F21 Chau Chak Wing Museum

(SSD 7894 F21 Chau Chak Wing Museum Building)

Consultation Report in accordance with the SEARS

CHAU CHAK WING MUSEUM, CAMPERDOWN CAMPUS CONSULTATION MEETING WITH THE CITY OF SYDNEY

Drawing Title
ELEVATION WEST - CONTEXT
Project Number
15037
Drawing Number
JPW-DA-A-2100
Documentation Stage
DEVELOPMENT APPLICATION
Revision
02

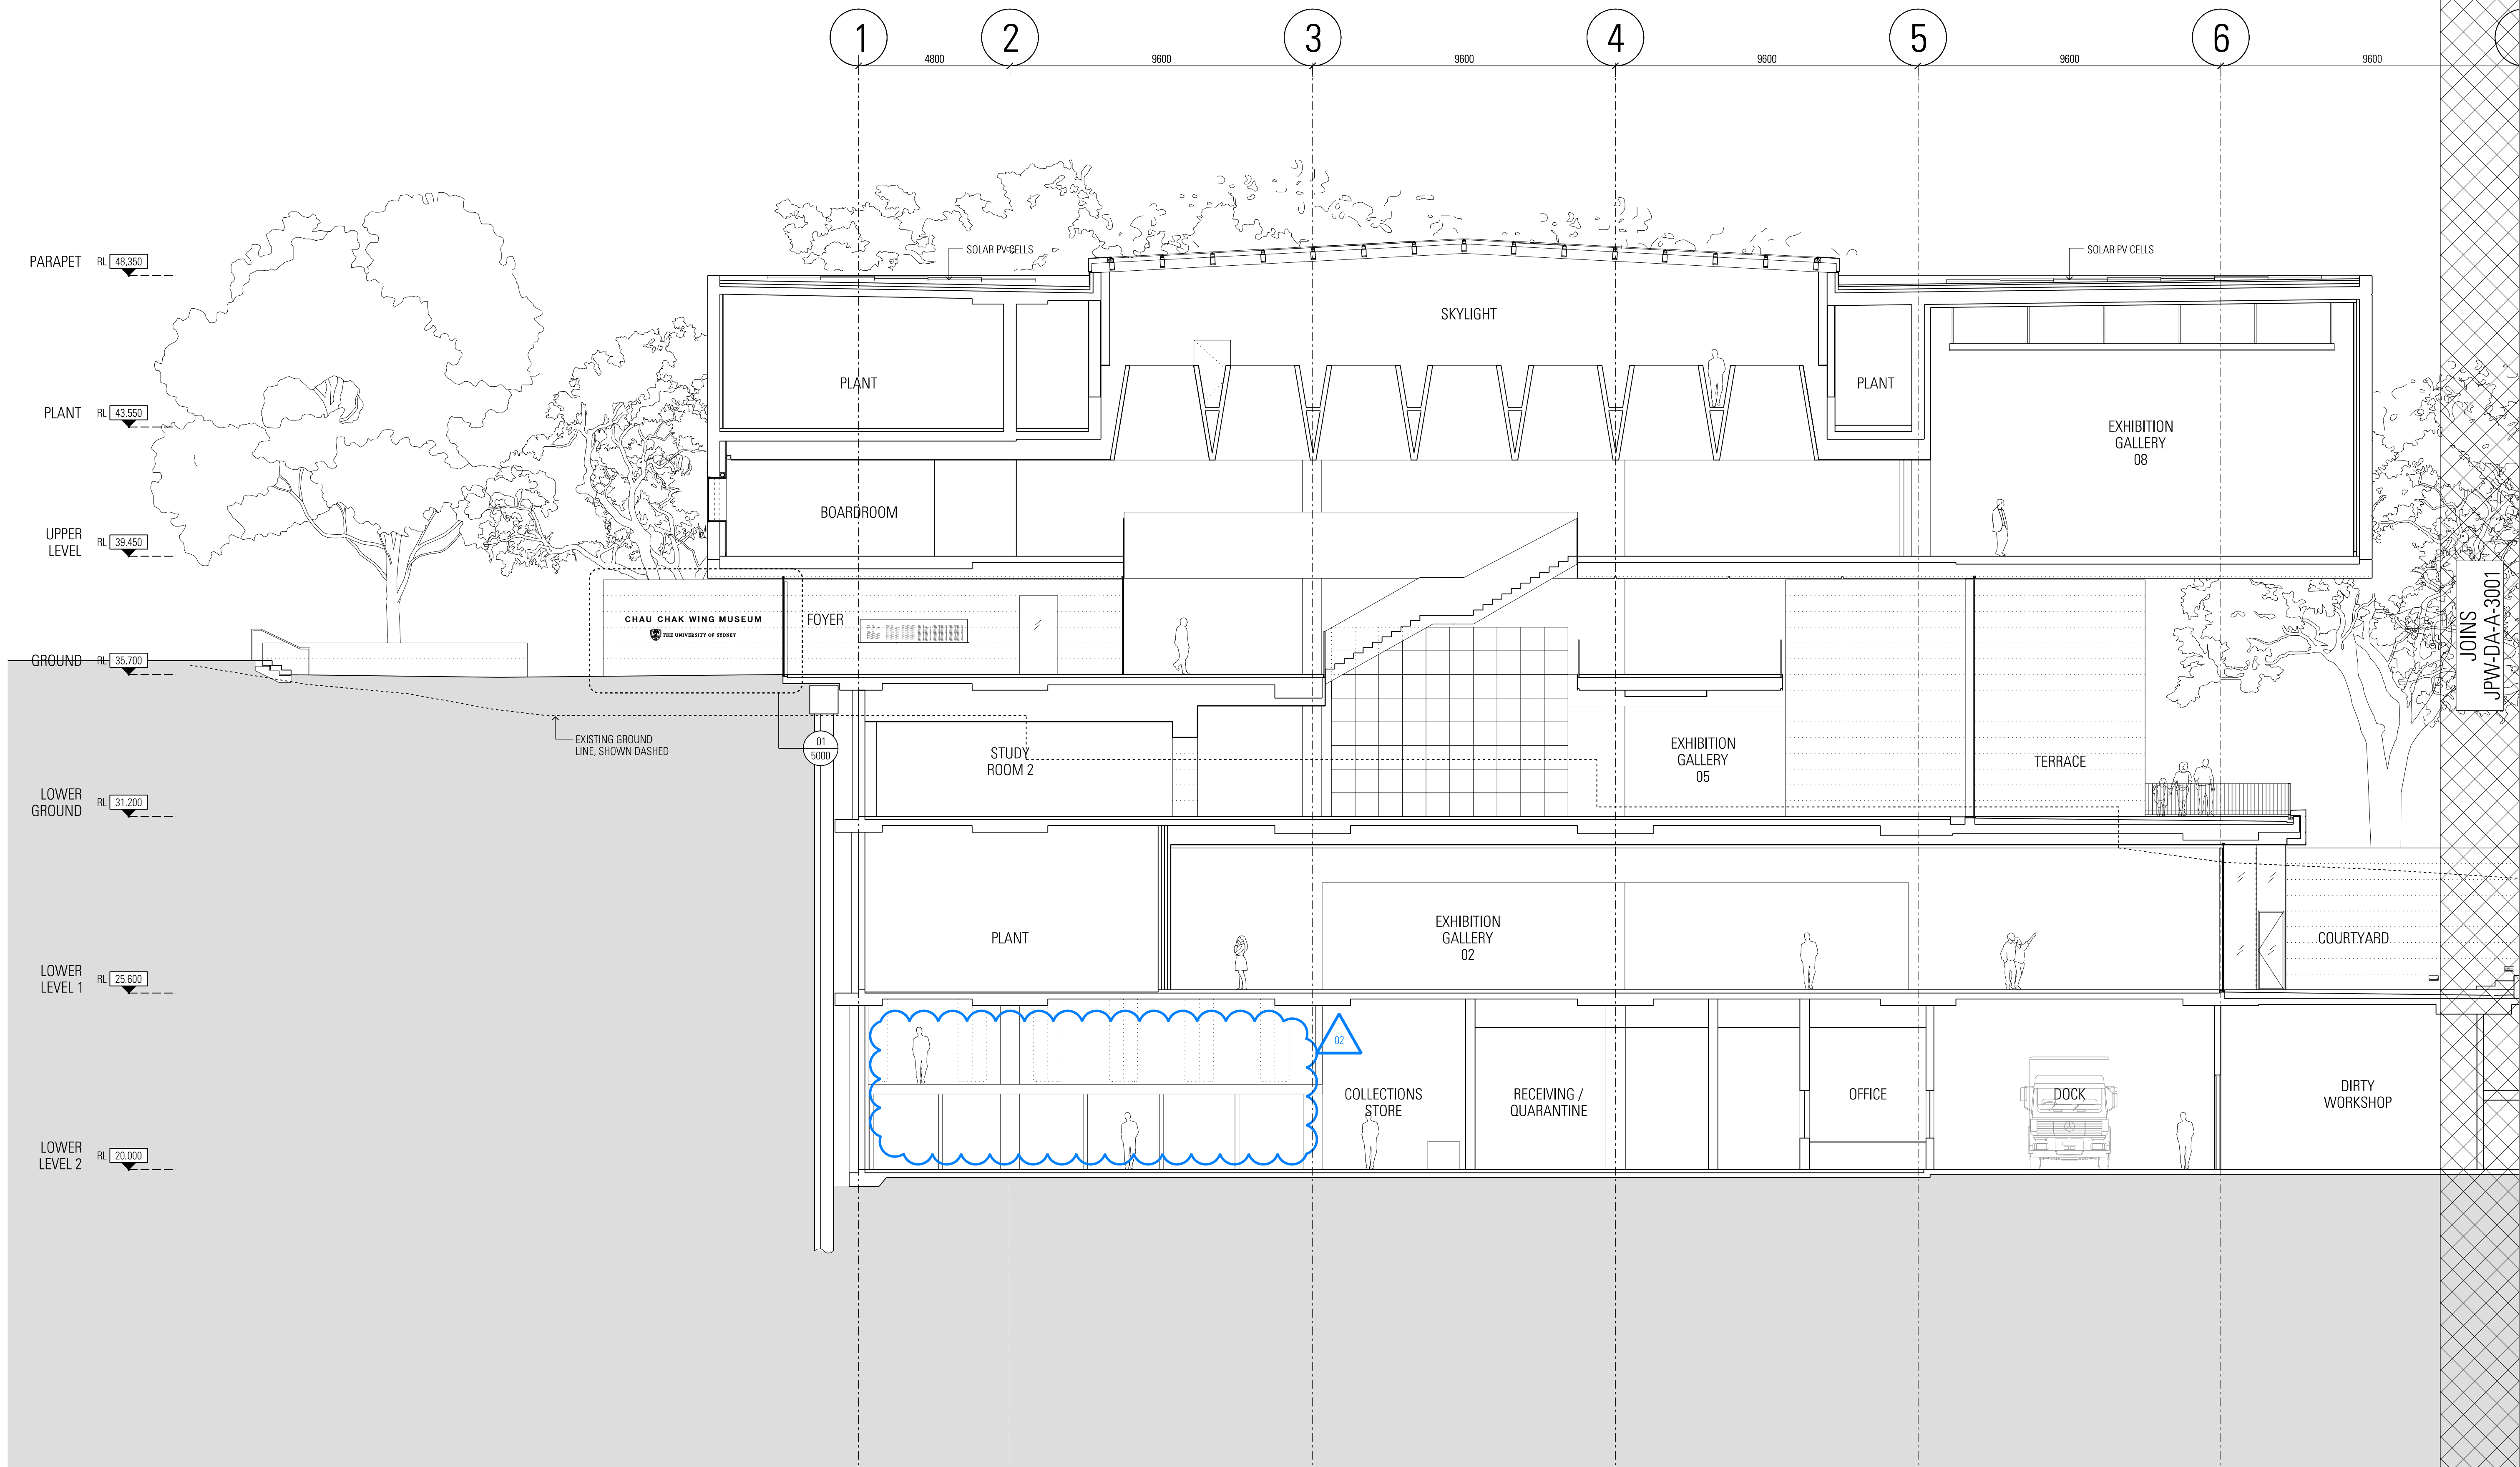
Heights with Fisher - not apparent in diagrams.

Show comparative elevation between CCW and Fisher Building.

Also compare height against facade of the Great Hall

G Dix - This will be reviewed and addressed e.g. potential to step back loading dock entrance, introduce a high quality and integrated materials palette and a series of stepped wall treatments, together with the integration of the existing ground cover (ivy).
